Response to Planning application from Hertfordshire County Council (T and CP GDP Order 2015)

District ref: 6/2023/2182/COND
HCC ref: WH/18817/2023
HCC received: 6 November 2023
Area manager: Matthew Armstrong
Case officer: Matthew Armstrong

Land to the north east of King George V Playing Fields Northaw Road East Cuffley EN6 4RD

Submission of details pursuant to condition number 14 (Theobalds Road Route) on planning permission S6/2015/1342/PP

DRAWING TITLE
S278 THEOBALD'S ROAD - SURFACE FINISHES PLAN

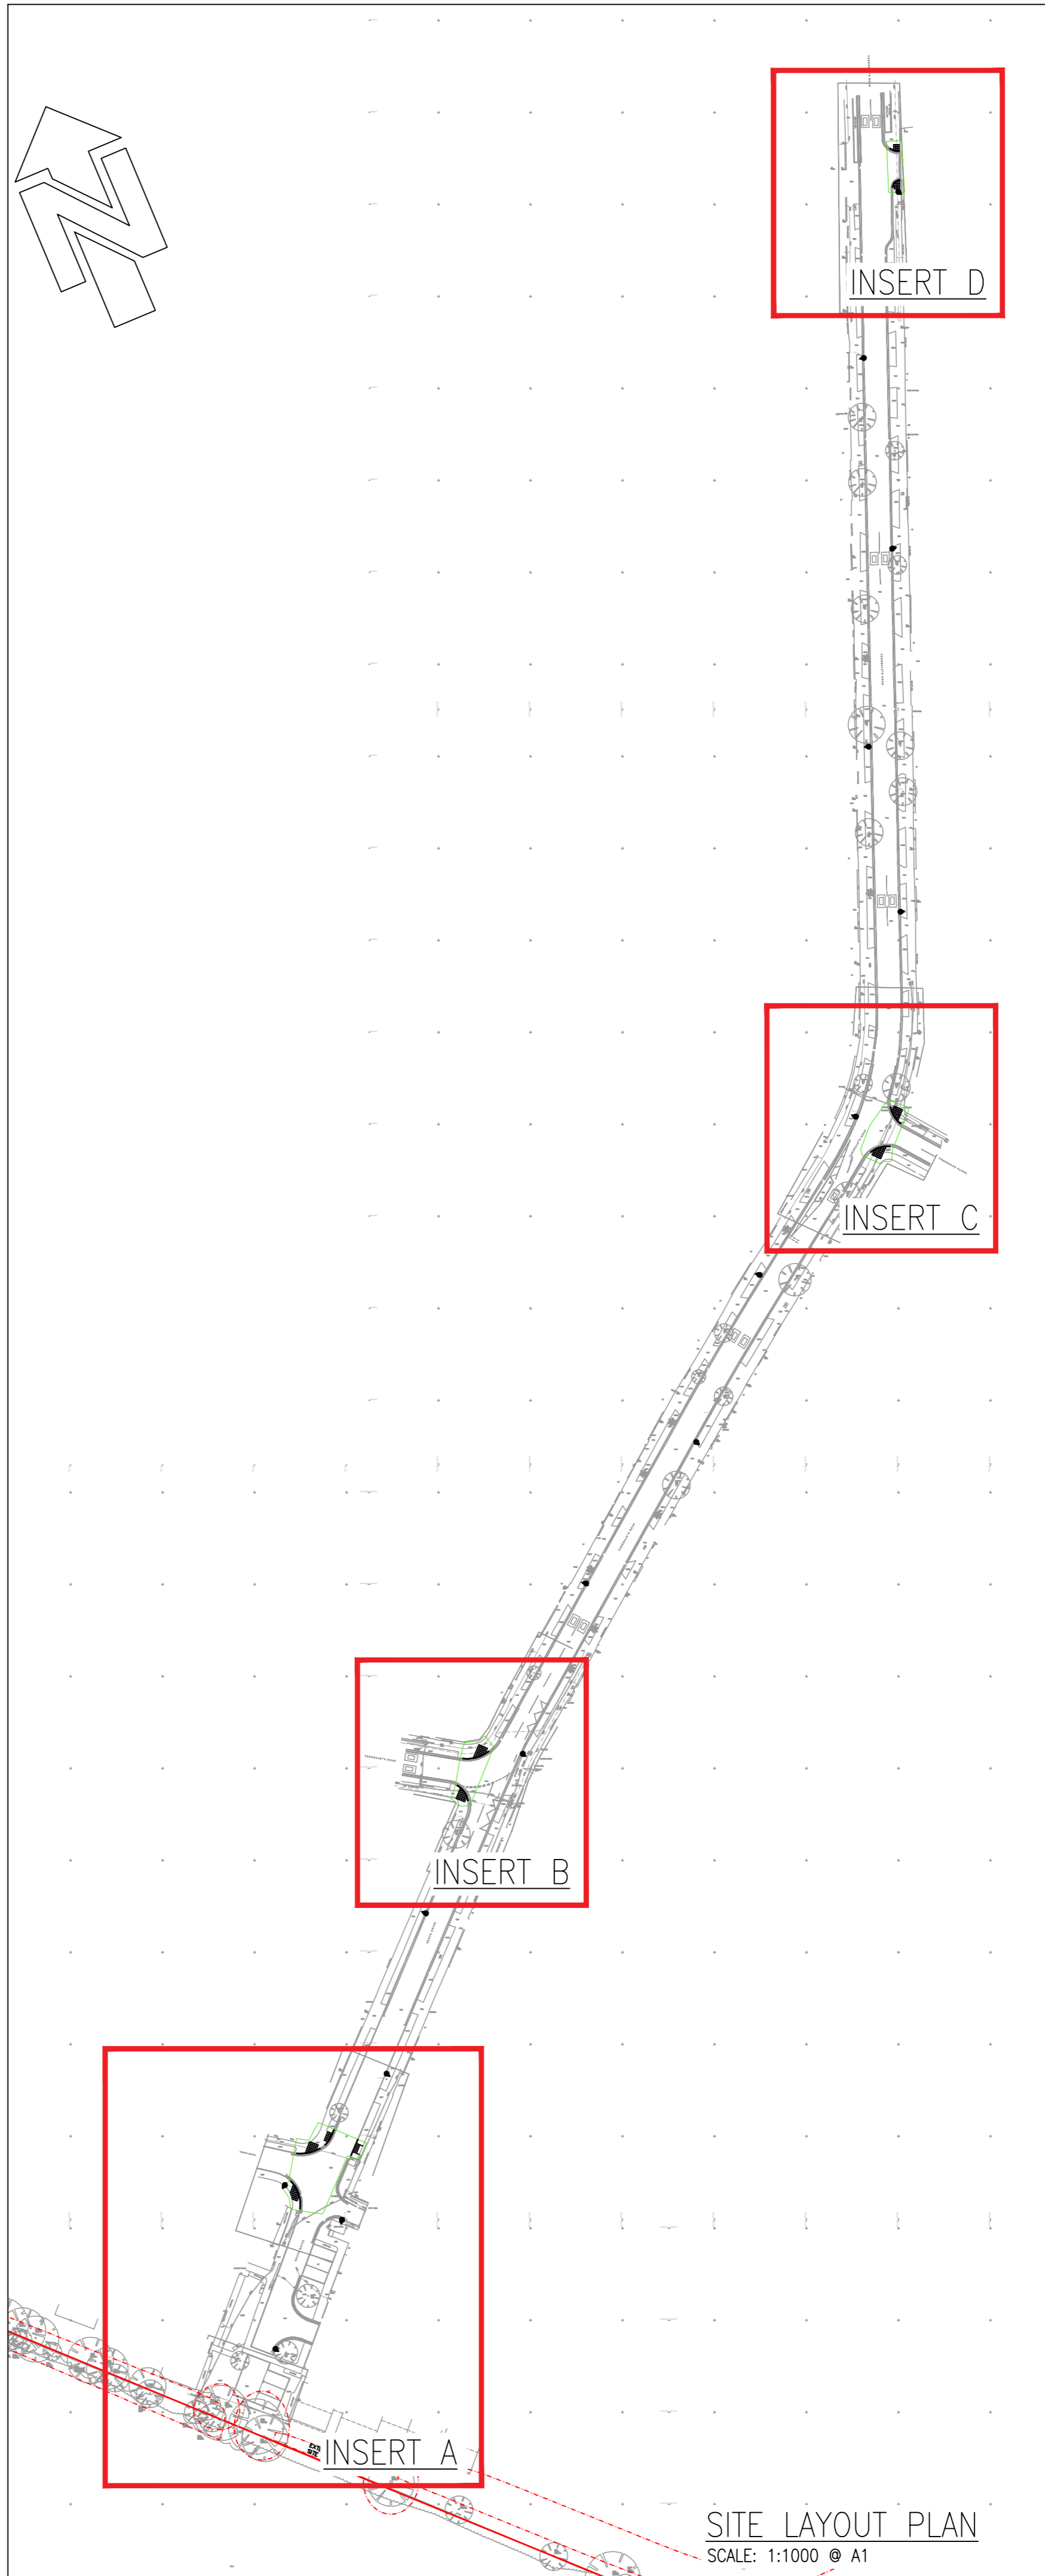
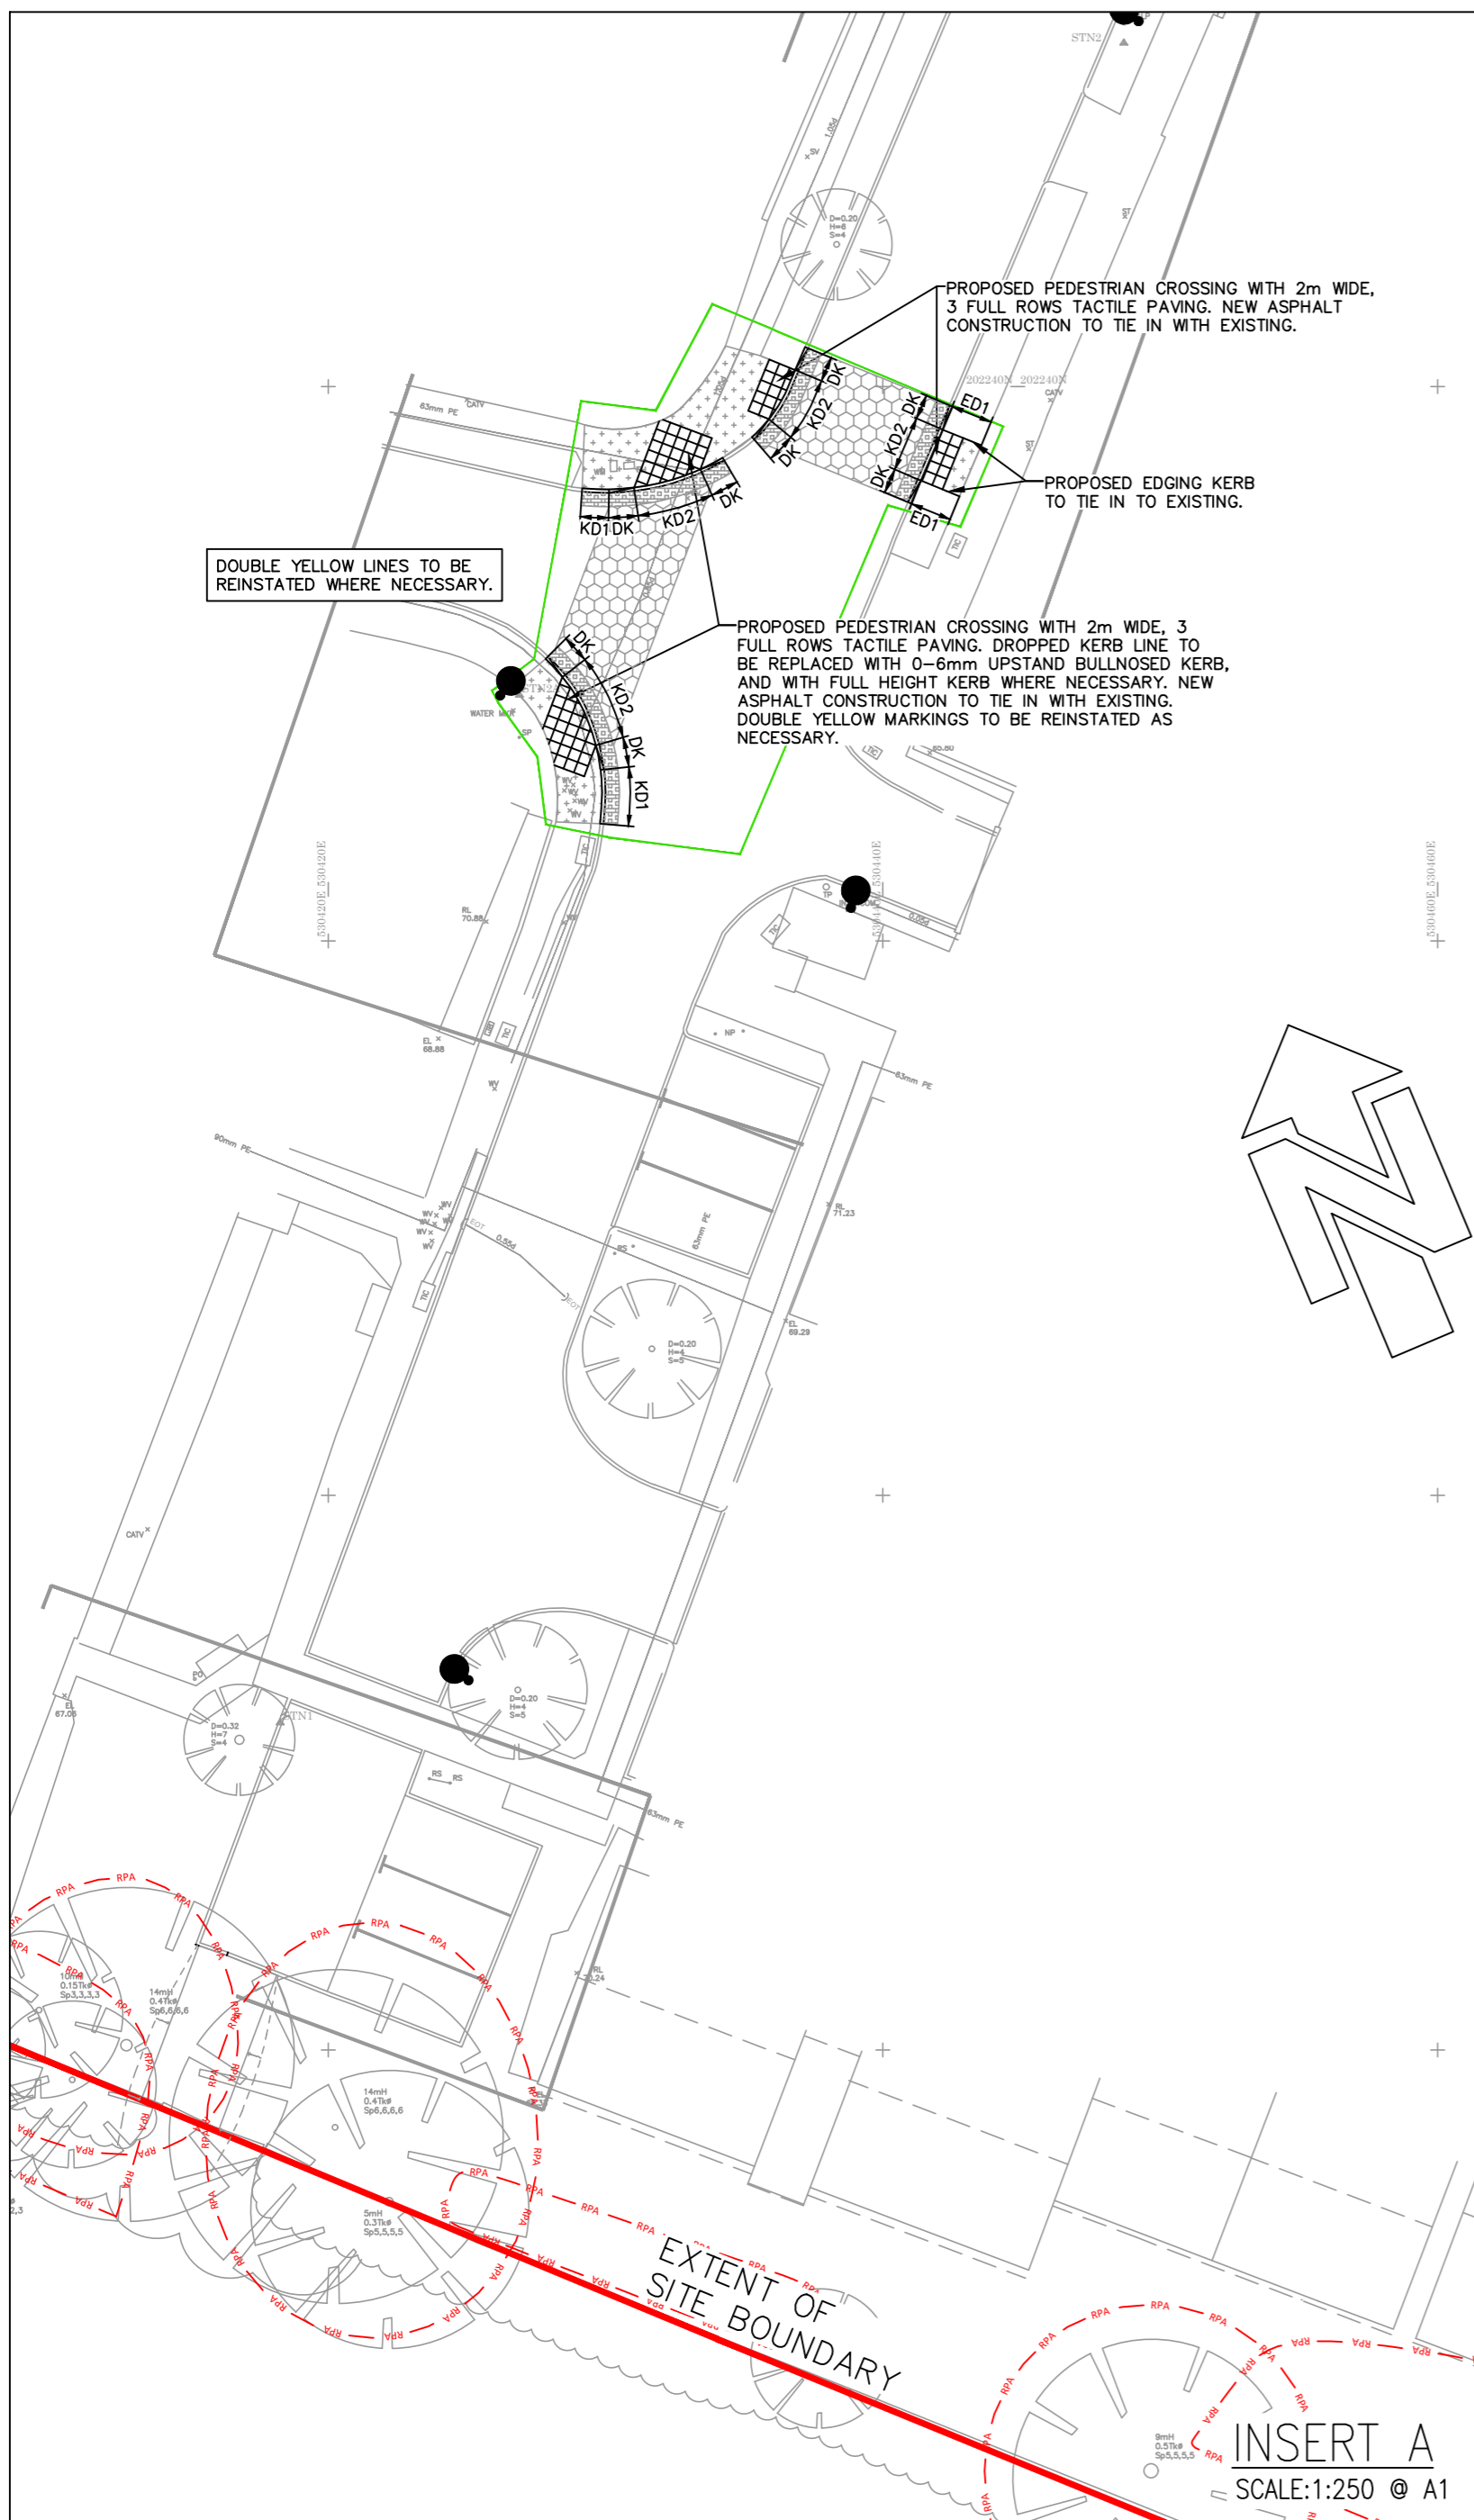
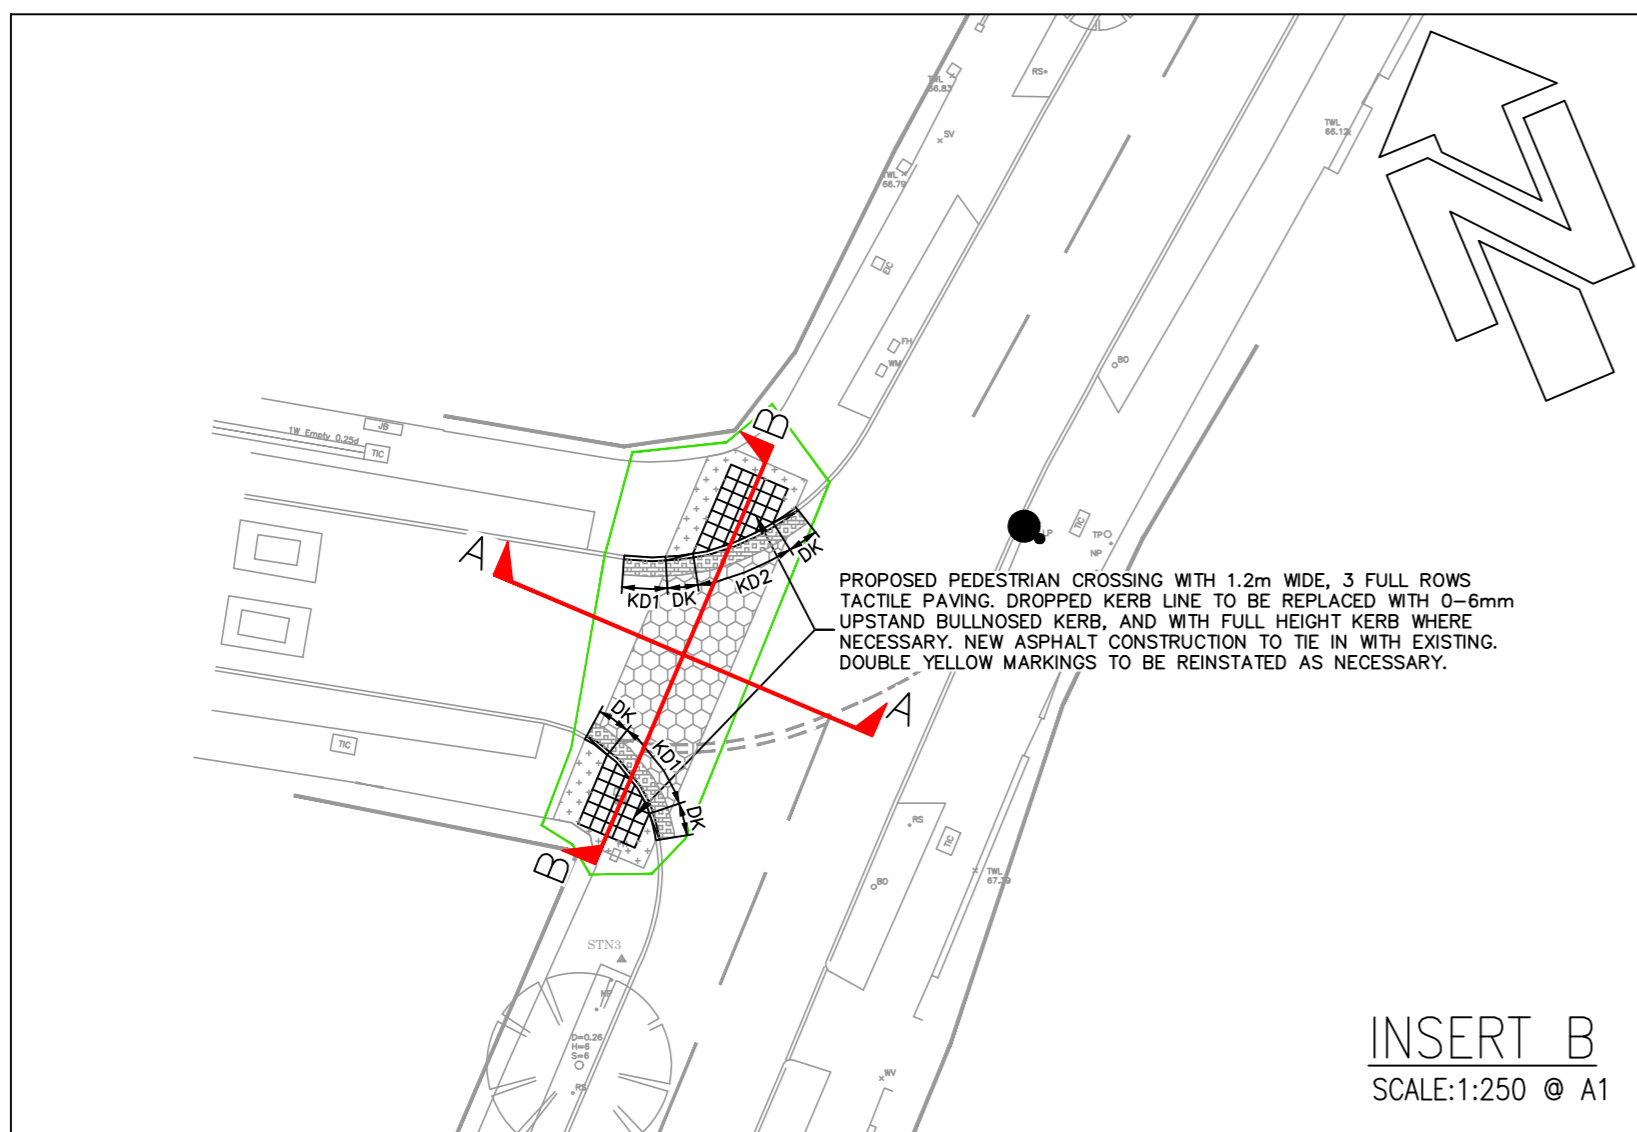
COMMENTS: The condition requires submission and approval of detailed engineering drawings (i.e. approved s278 plans). For this planning application, the applicant has submitted earlier s278 plans which have not received Technical Approval. As part of the stage 2 Road Safety Audit / s278 process, it was identified that there is a need for these plans to be revised, albeit only slightly. Once the latest s278 plans (with Technical Approval) are submitted as part of this discharge of condition application, the first part of the condition can be discharged. As the works are not in place on the ground, it is premature to discharge the second part of the condition.
